**Our Case Number:** ABP-315708-23

**Planning Authority Reference Number:** 2250933

**Date:** 15 December 2023

**Re:** Demolition of existing concrete structure and the quarrying of 5.37 hectares which will be subject to extraction and processing of rock through drilling, blasting, crushing and screening and all associated ancillary facilities/works over a 25 year period. An Environmental Impact Assessment Report and Natura Impact Statement accompanies this application. Magherasolis and Craigs, Raphoe, Lifford PO, Co. Donegal.

Drawing Title:
Realignment of Junction at R236-6

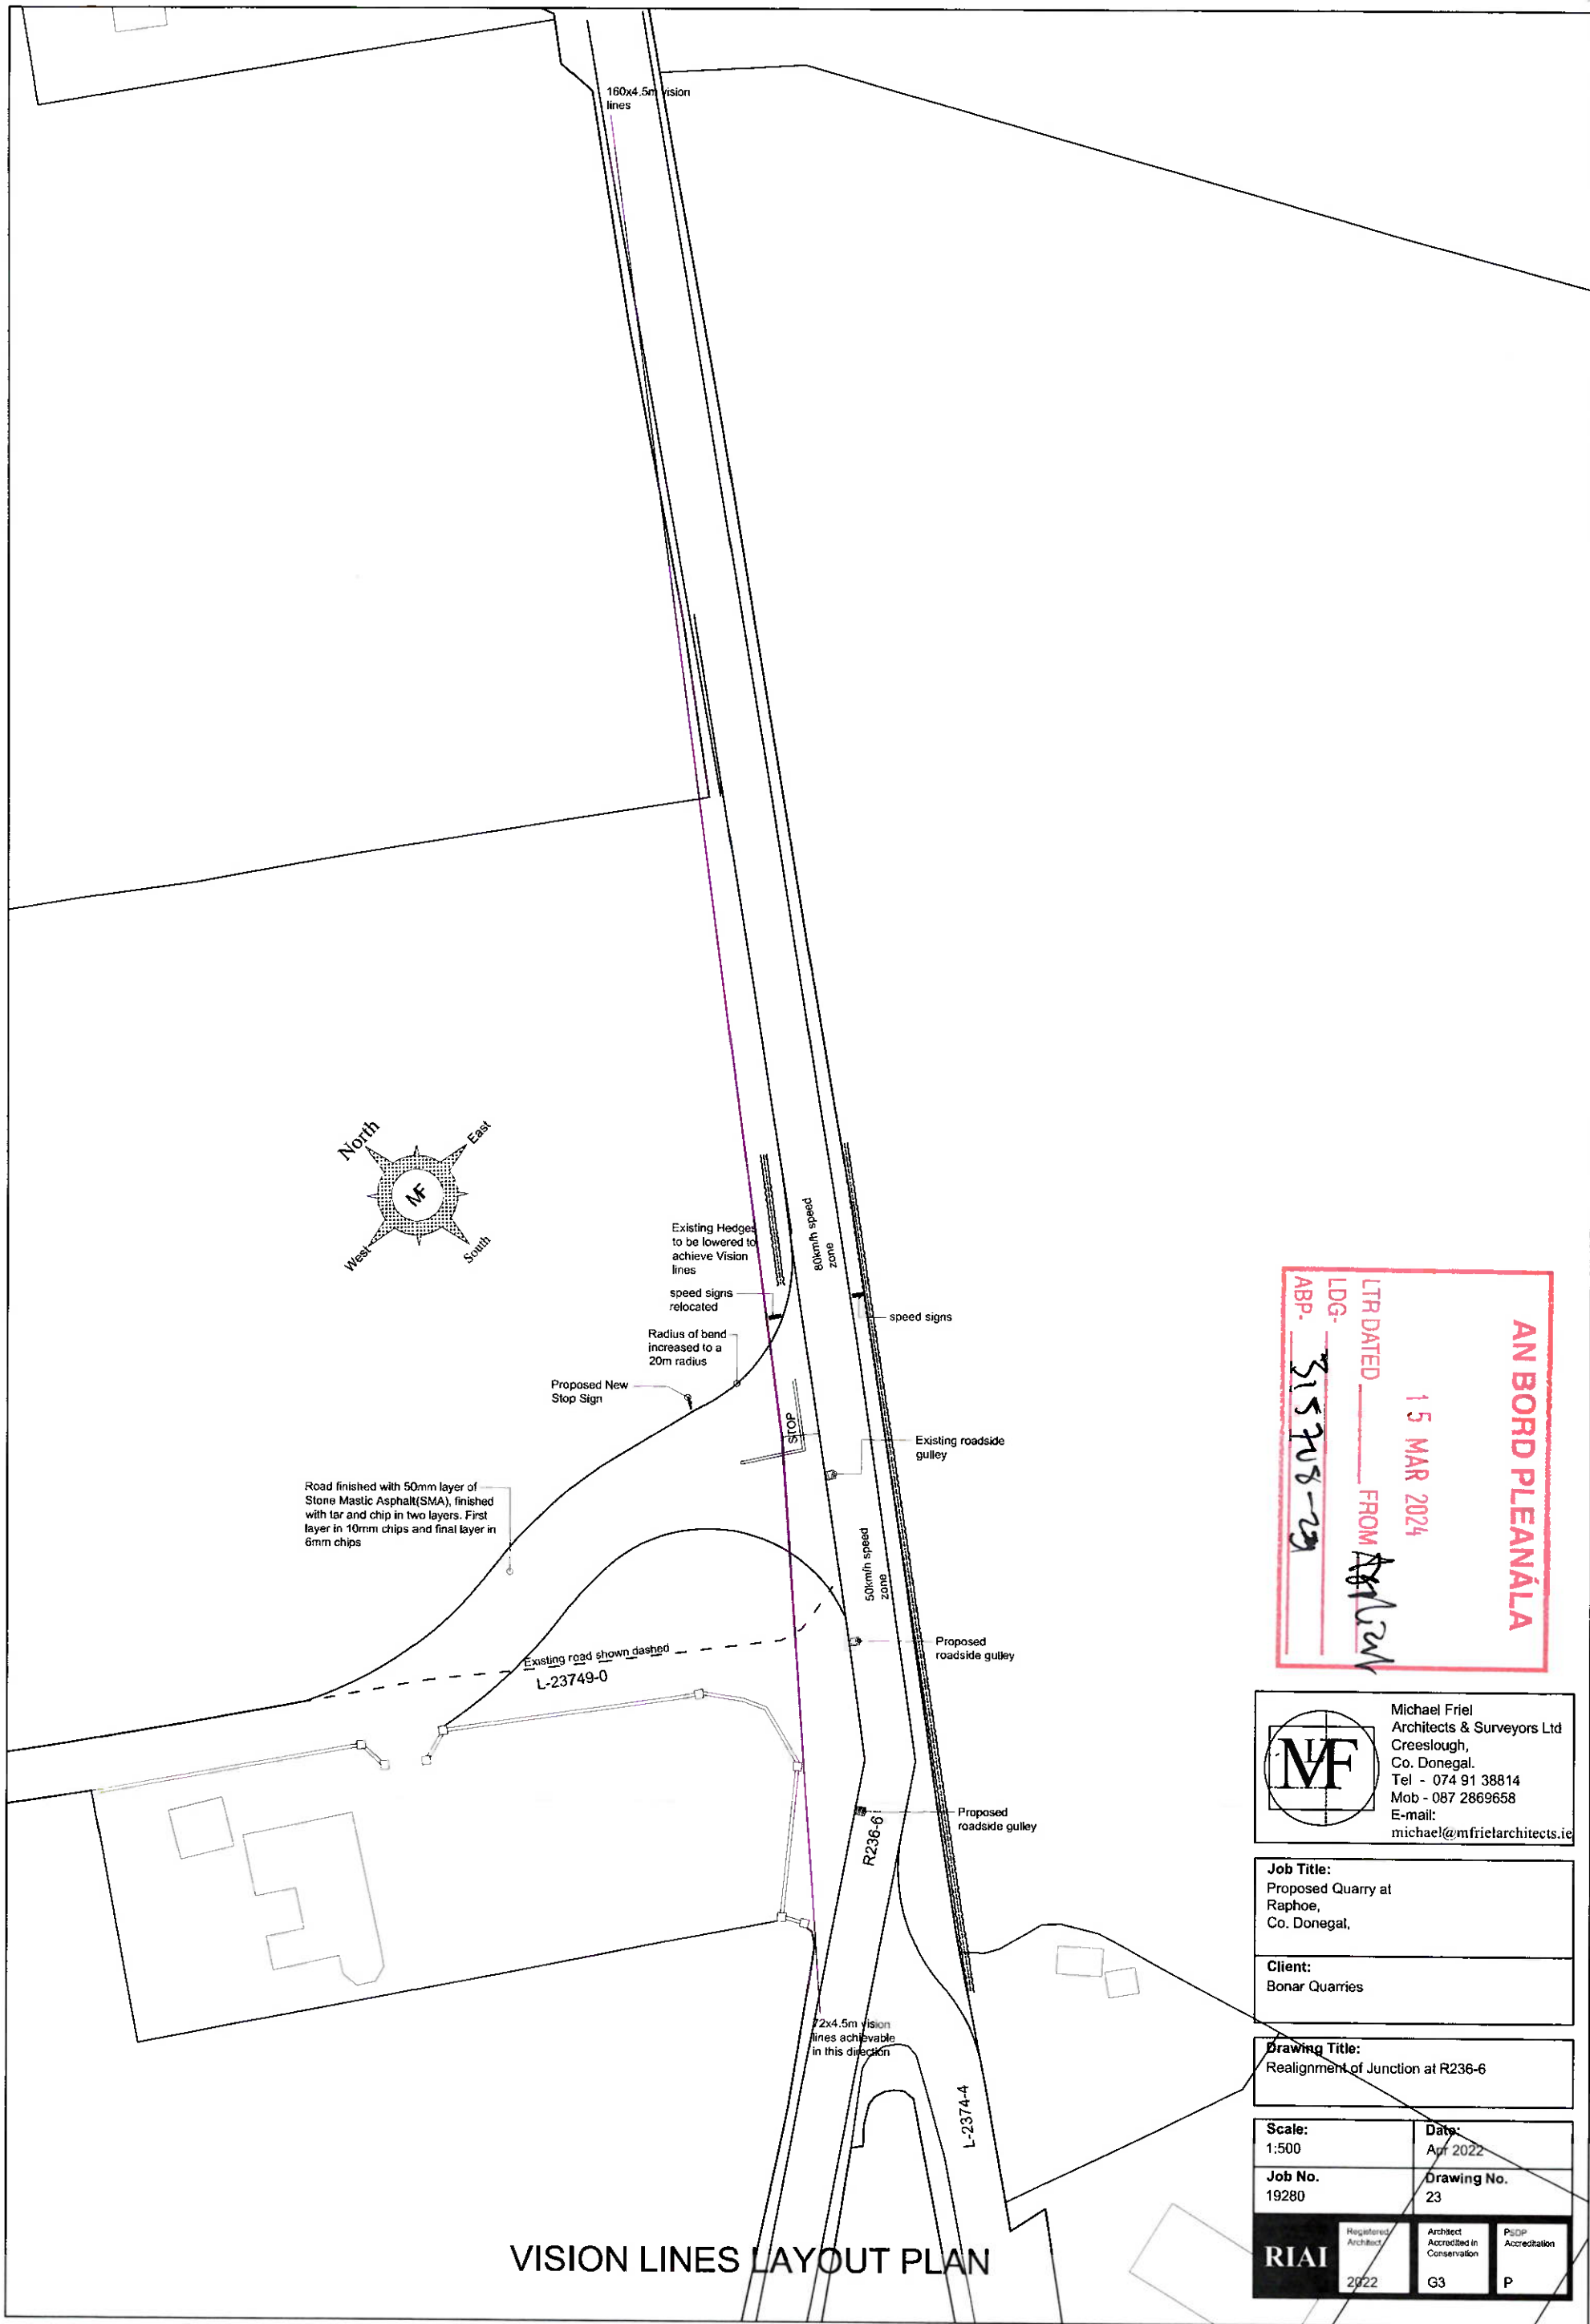
- Please clarify the improvements proposed for the means of access to the site, i.e., the local road and its onward extension into the site, by means of a detailed site survey plan and elucidating cross-sections. This plan and these cross-sections shall indicate how the means of access would be drained and the relationship between it and the land drain, which would receive the discharge from the site. Any removal of existing vegetation to improve forward visibility shall be specified, too.
